March 19, 1992

RE: REVISED DRAINAGE PLAN FOR AN ADDITION TO THE LOVELACE  
NEURO BEHAVIORAL CENTER (D-17/D3A) REVISION DATED MARCH 3, 1992

RE: CONCEPTUAL GRADING & DRAINAGE PLAN FOR LOVELACE NEURO-  
BEHAVIORAL HOSPITAL (D-17/D3A) ENGINEER'S STAMP DATED  
OCTOBER 1, 1991

CONCEPTUAL GRADING & DRAINAGE PLAN UPDATE
LOVELACE NEURO-BEHAVIORAL HOSPITAL

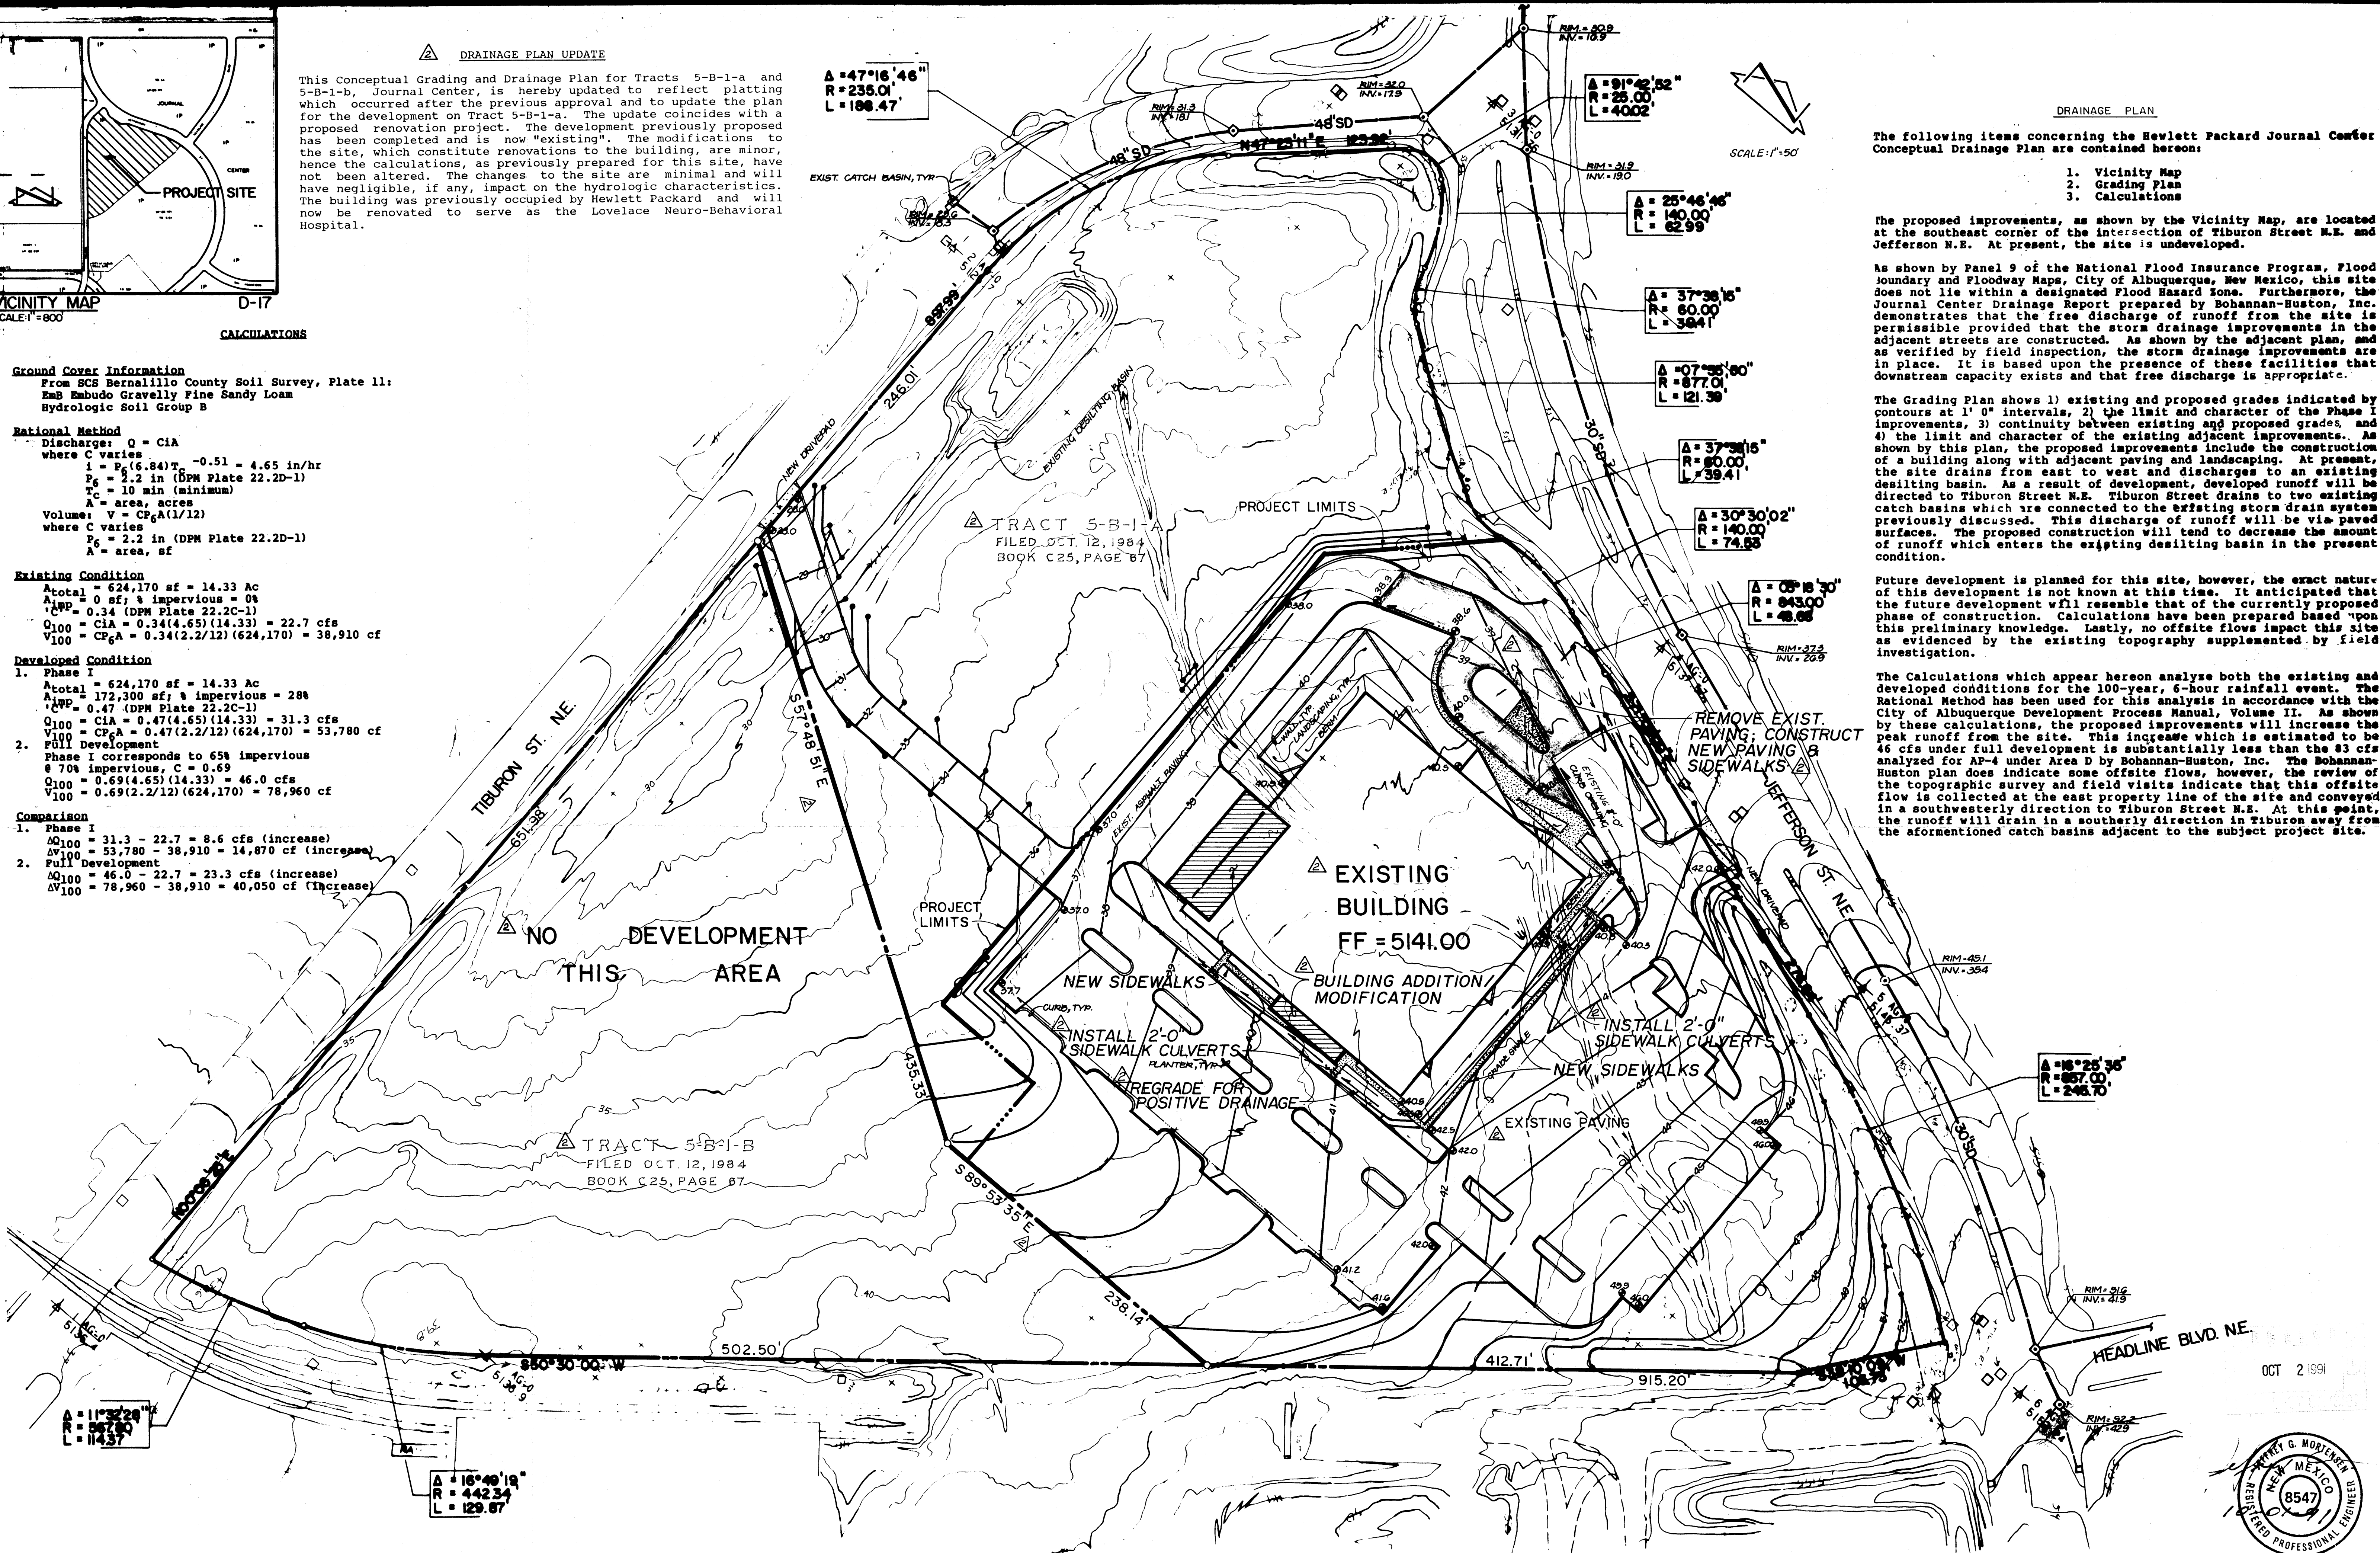
1. Location and direction of roof drains.
2. More spot elevations within your flow arrows to clarify to contractor the grading required.
3. What are the limits of Phase I? Please indicate on the plan drawing.
